KITTITAS COUNTY DEPARTMENT OF PUBLIC WORKS

MEMORANDUM

TO: Graham Simon, Community Development Services Planner II
FROM: Randy Carbary, Planner II ✓
DATE: Oct 20, 2005
SUBJECT: Bailes BLA

**BAILES PROPERTY**

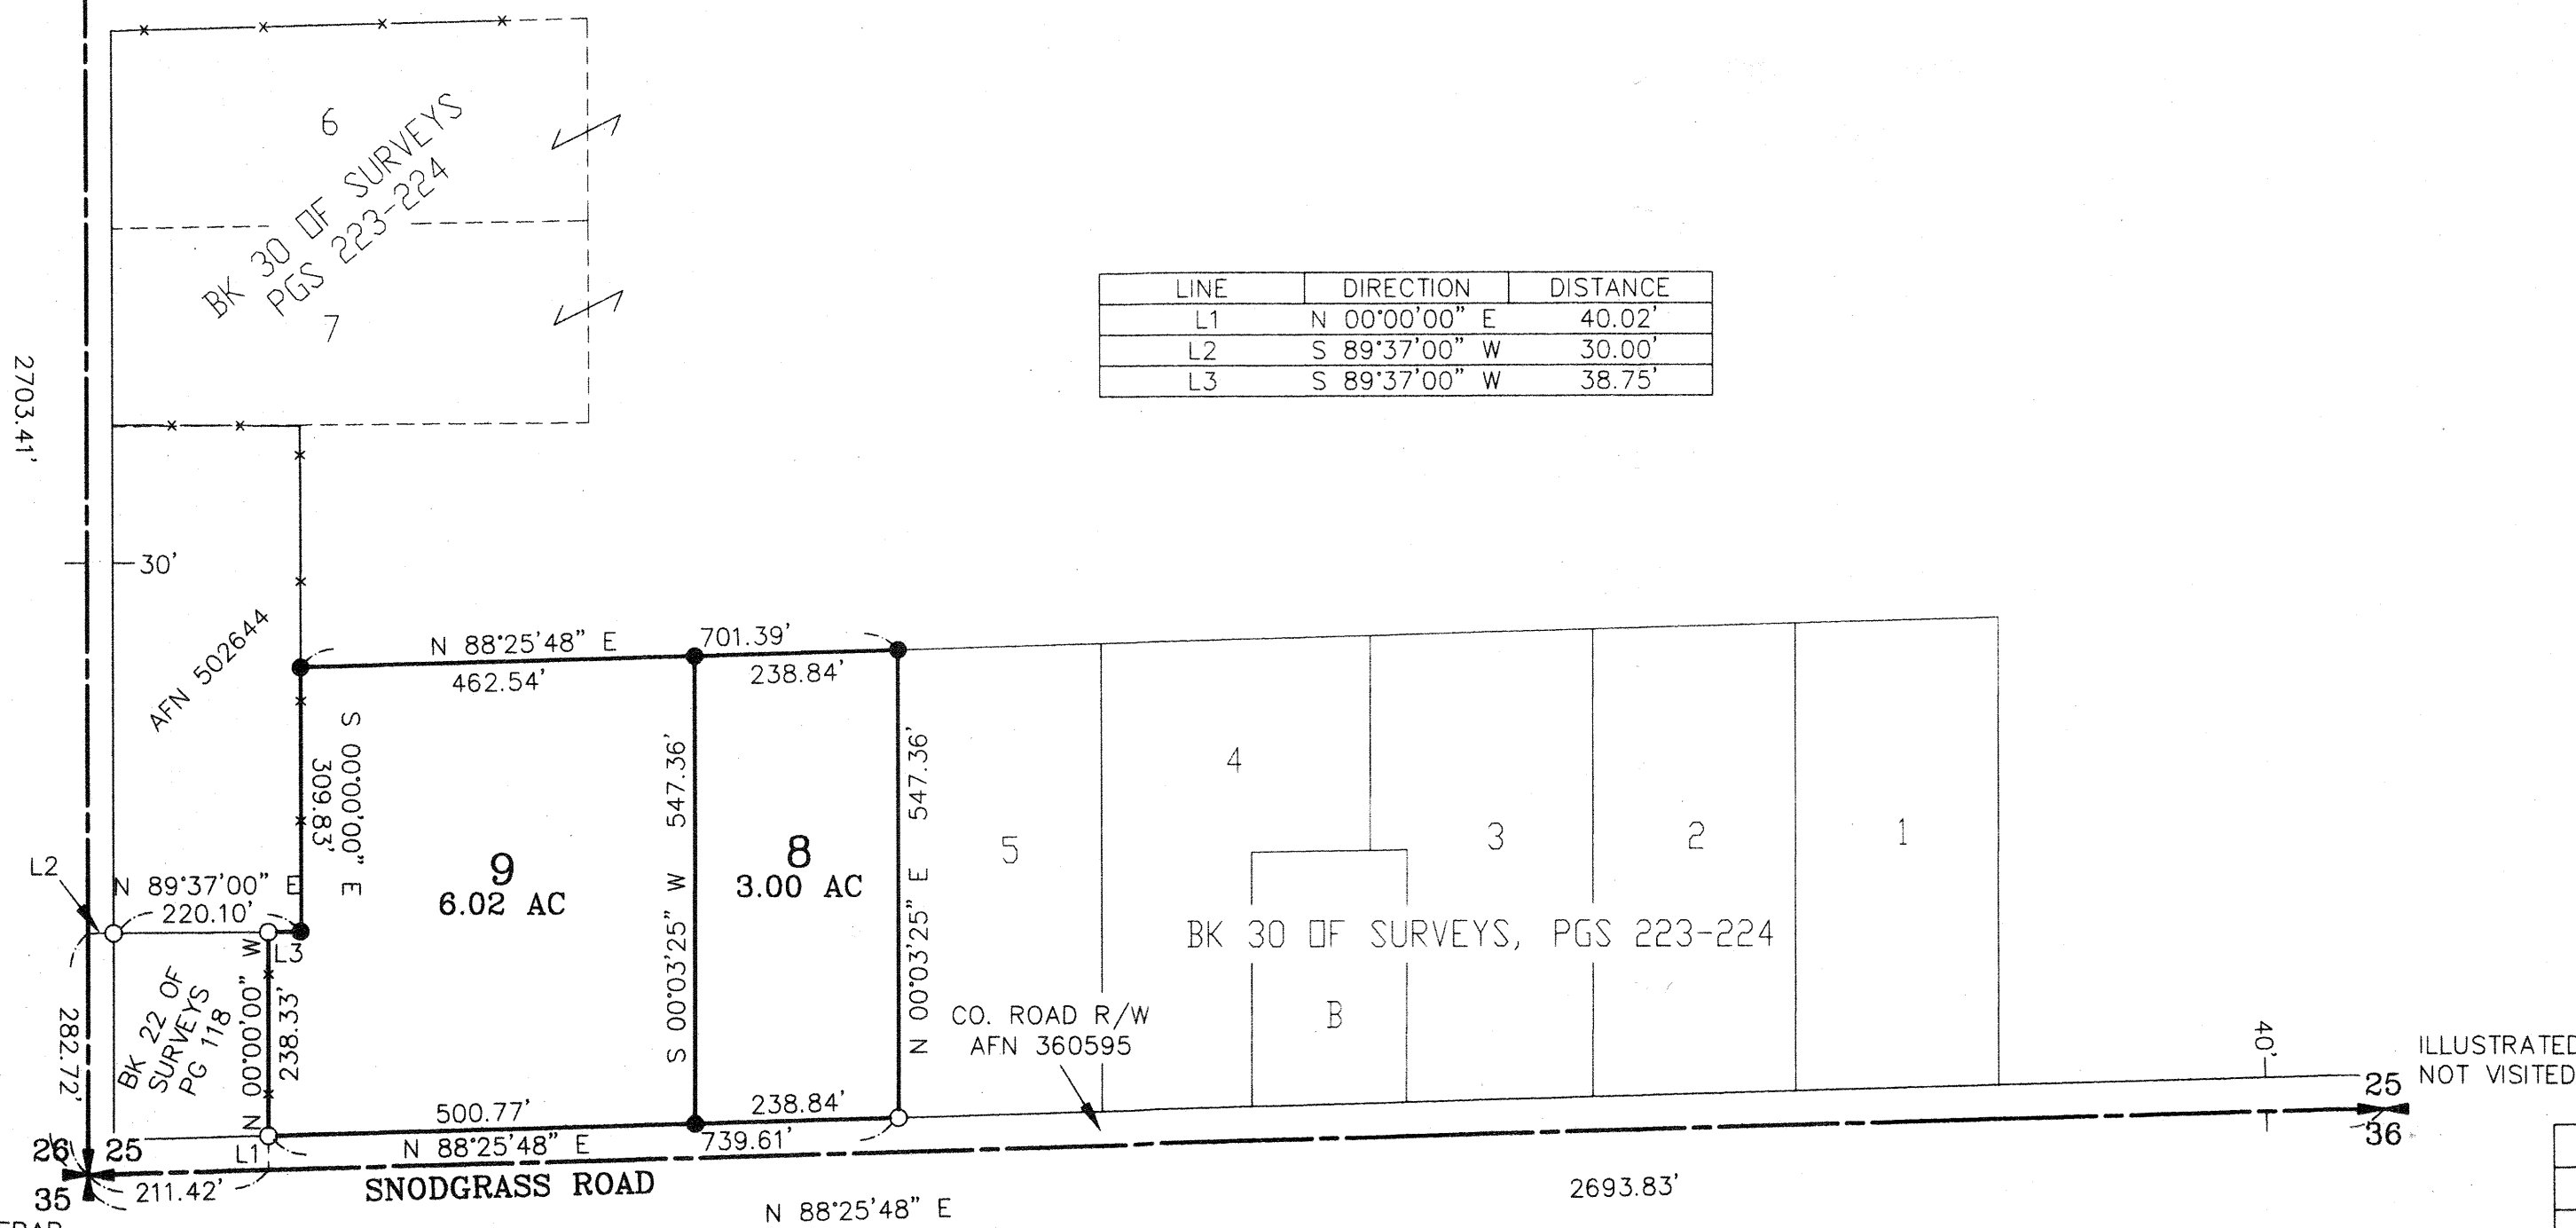
1. Prior to Final Approval the proposed access with appropriate easement(s) shall be shown and shall conform to applicable Kittitas County Road Standards.
